November 19, 2018

Nina Ruiz  
PM/Planner II  
El Paso County Planning and Community Development

This letter responds to comments uploaded on EDARP in November. Our responses to comments are provided in **red** below.

MULE DEER INVESTMENTS, LLC
ZONE: CS

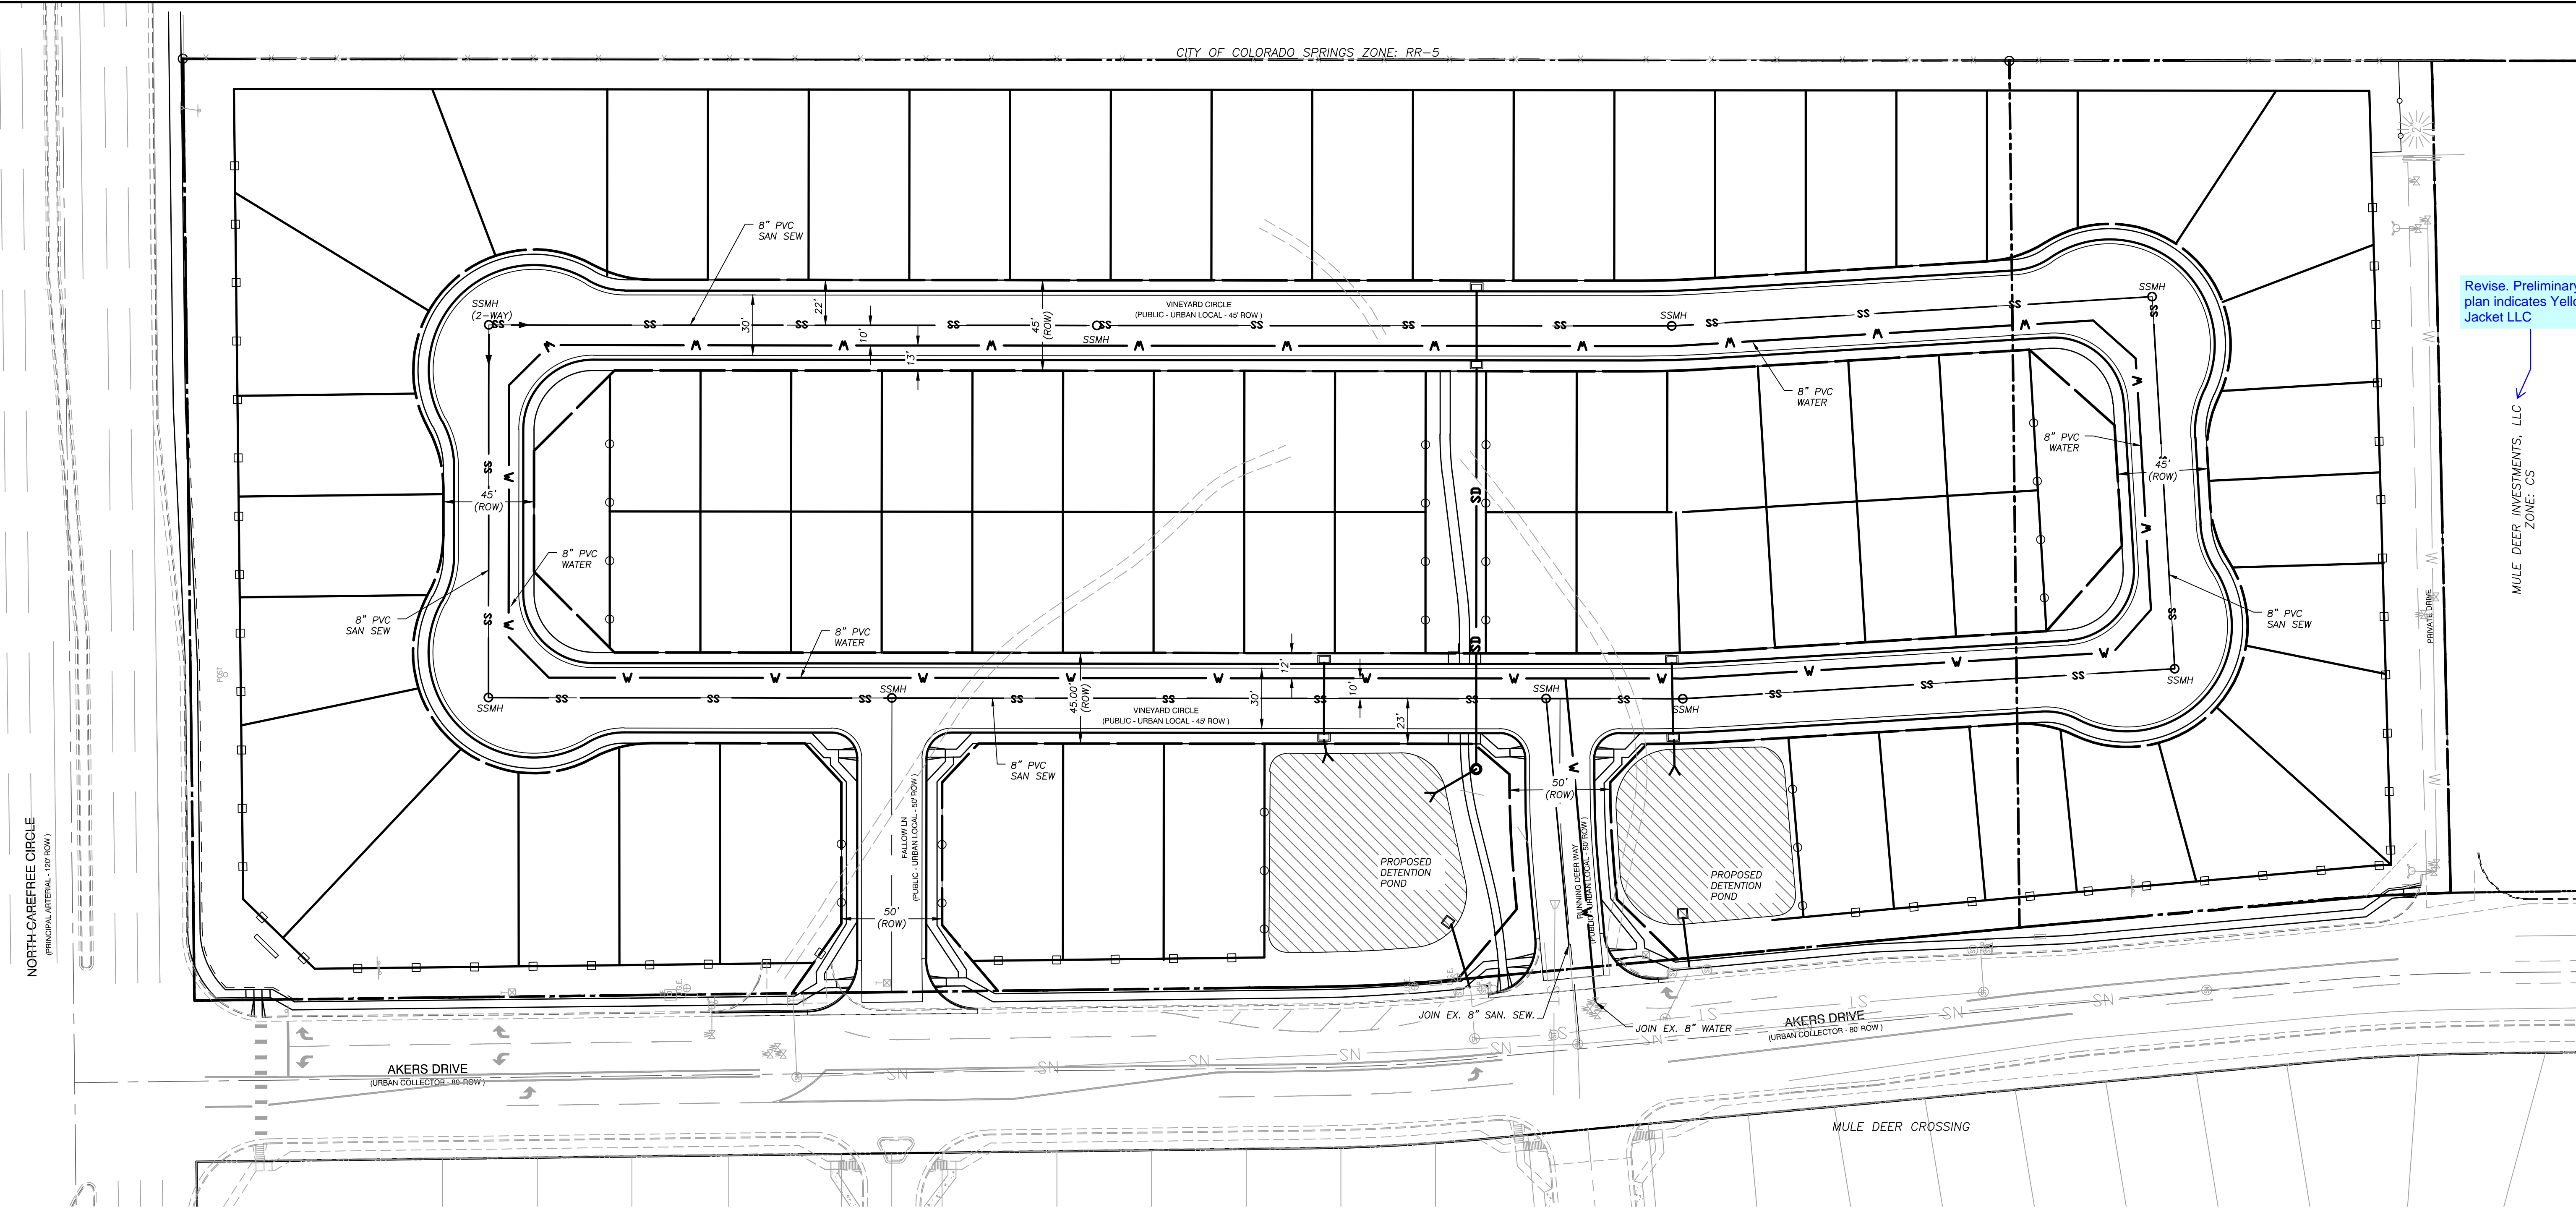
Fire Lane Signs Required: Roadways proposed in this subdivision are less than 34 feet wide and will require fire lane no parking signs on one side of the road throughout the entire subdivision. The inside road is where the fire hydrants are proposed and should be where the no parking fire lane markings are posted as well. See notes below for more information.

- The inner curb of Vineyard Circle has been marked and noted as a "FIRE LANE NO PARKING".

**THE GARDENS AT
NORTH CAREFREE**
PUD DEVELOPMENT/
PRELIMINARY PLAN
El Paso County, CO

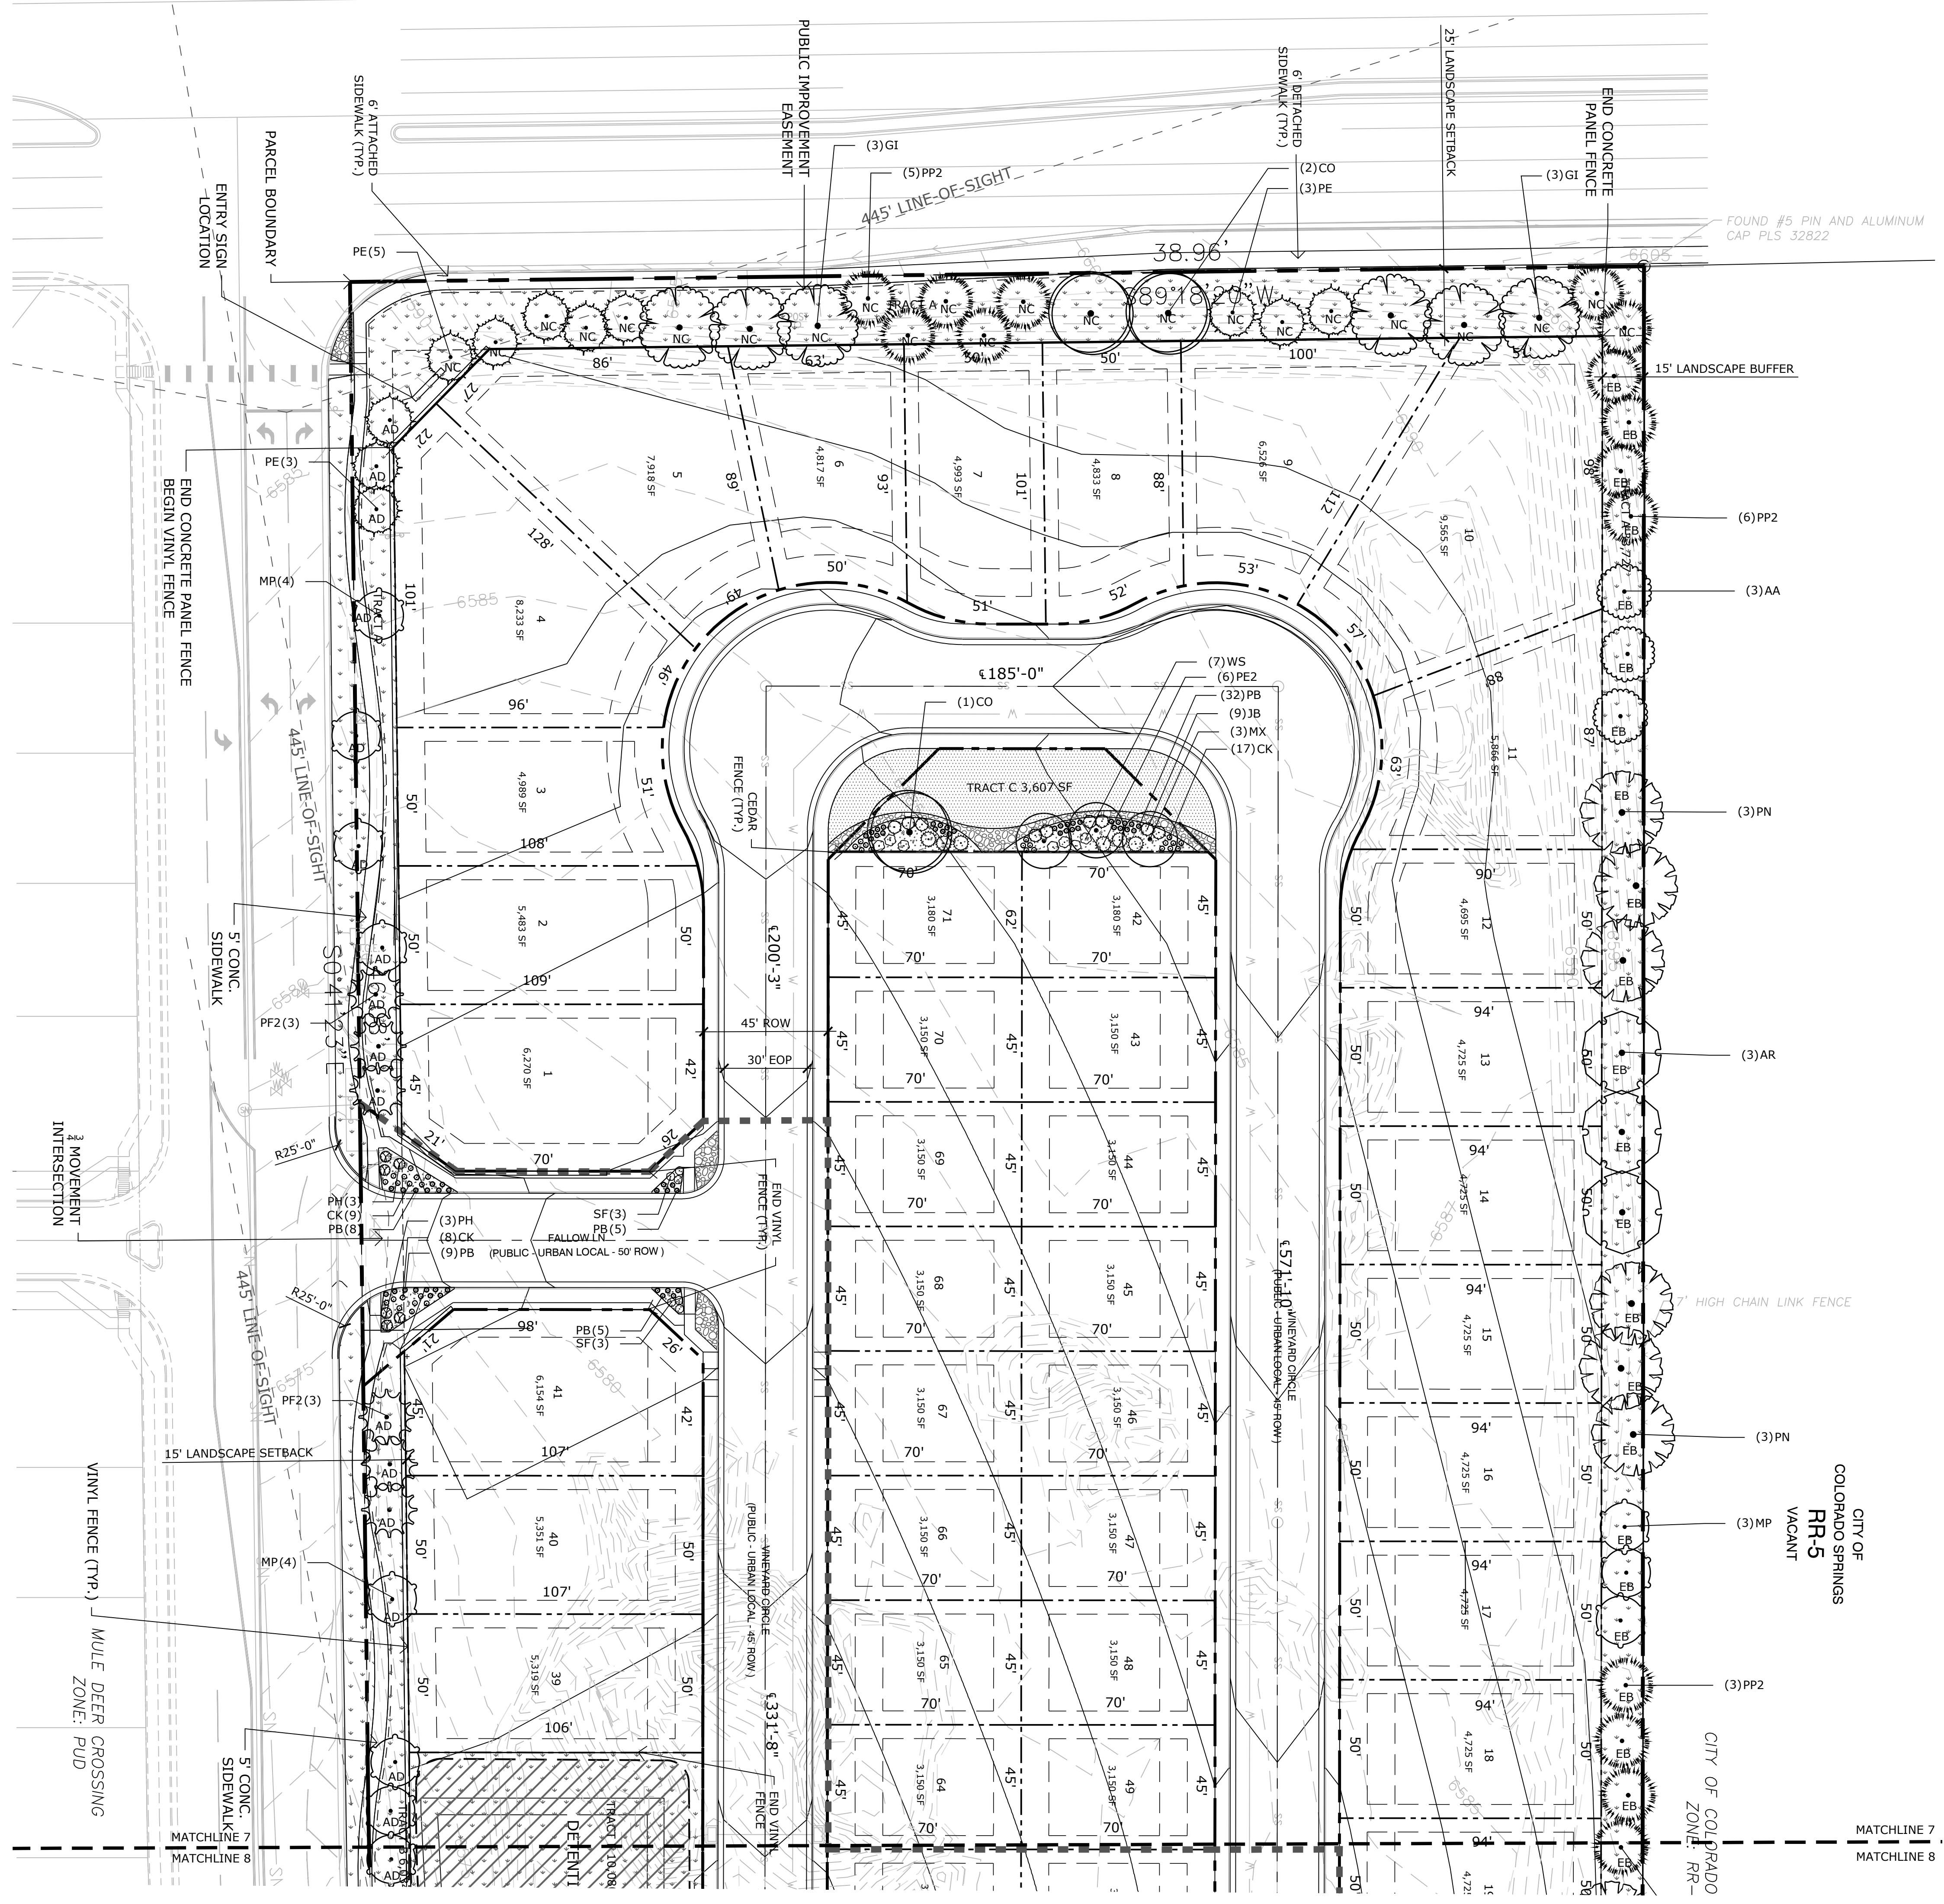
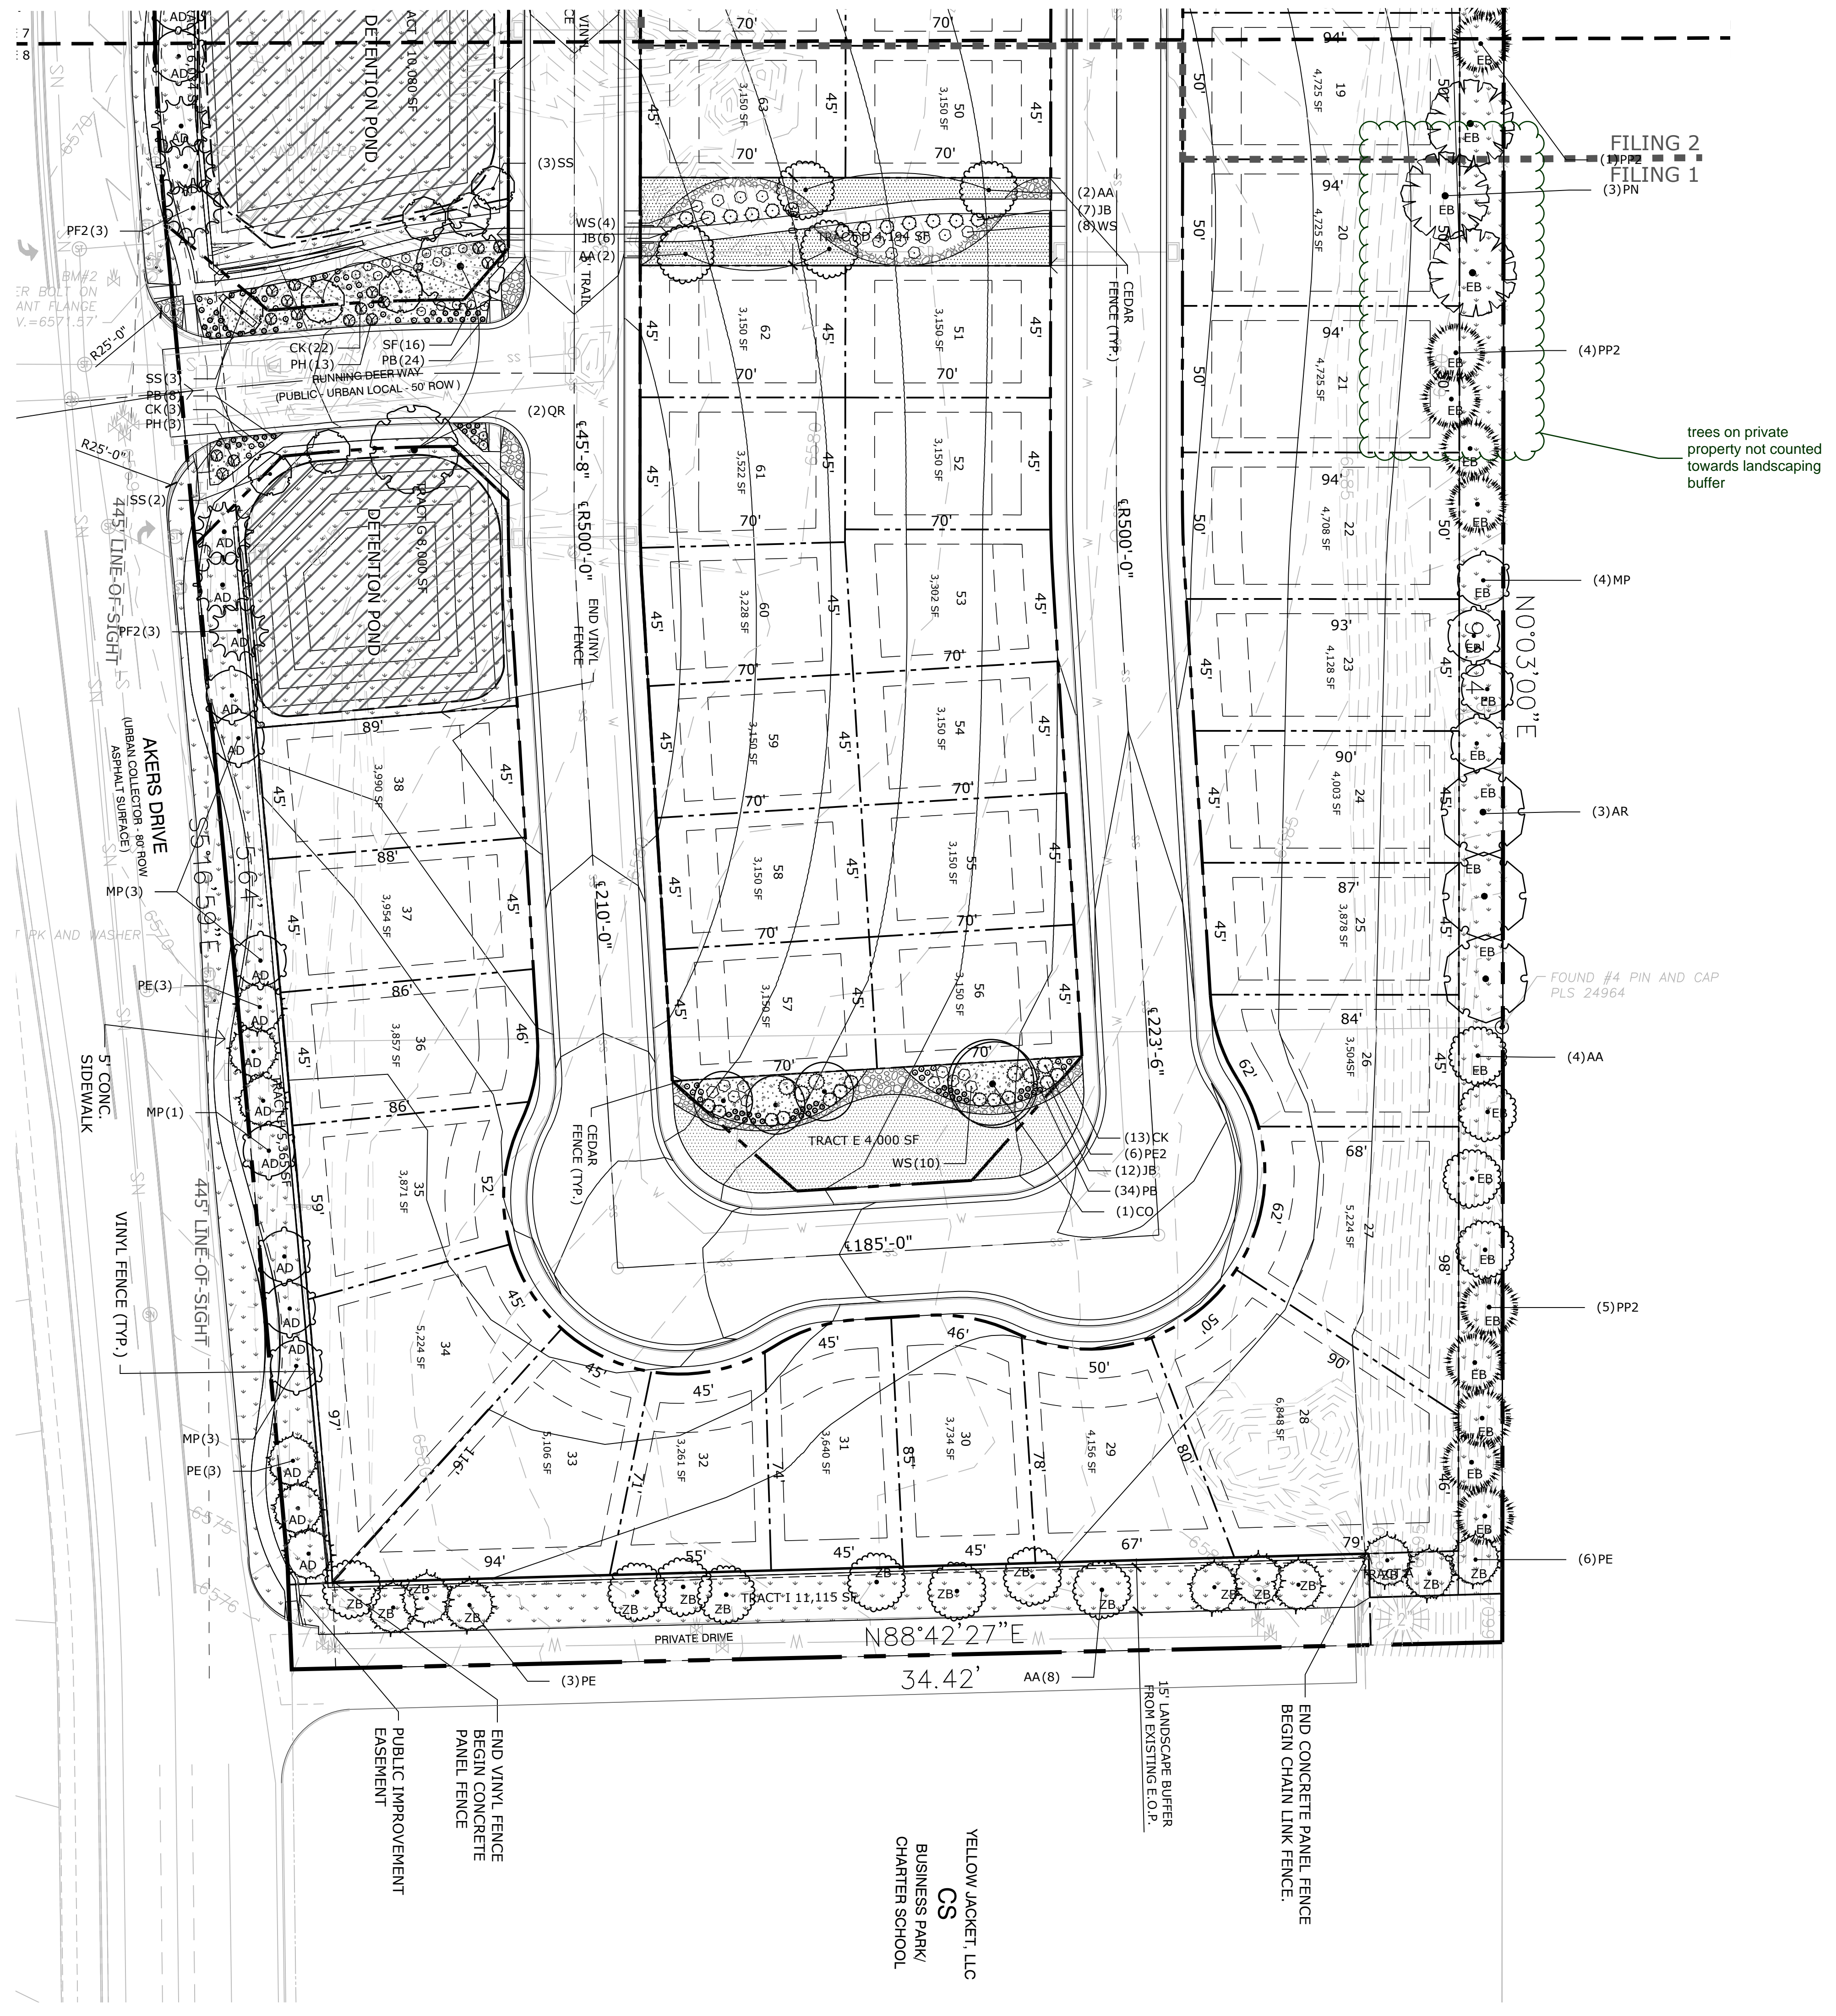
1. There are several trees/shrubs shown on private property and not within the landscape areas. These trees should be removed, as they are beyond the landscape areas. Homeowners/developers may install any number of trees they wish on personal property.

- **The trees have been relocated/shifted east to be outside of the lot.**
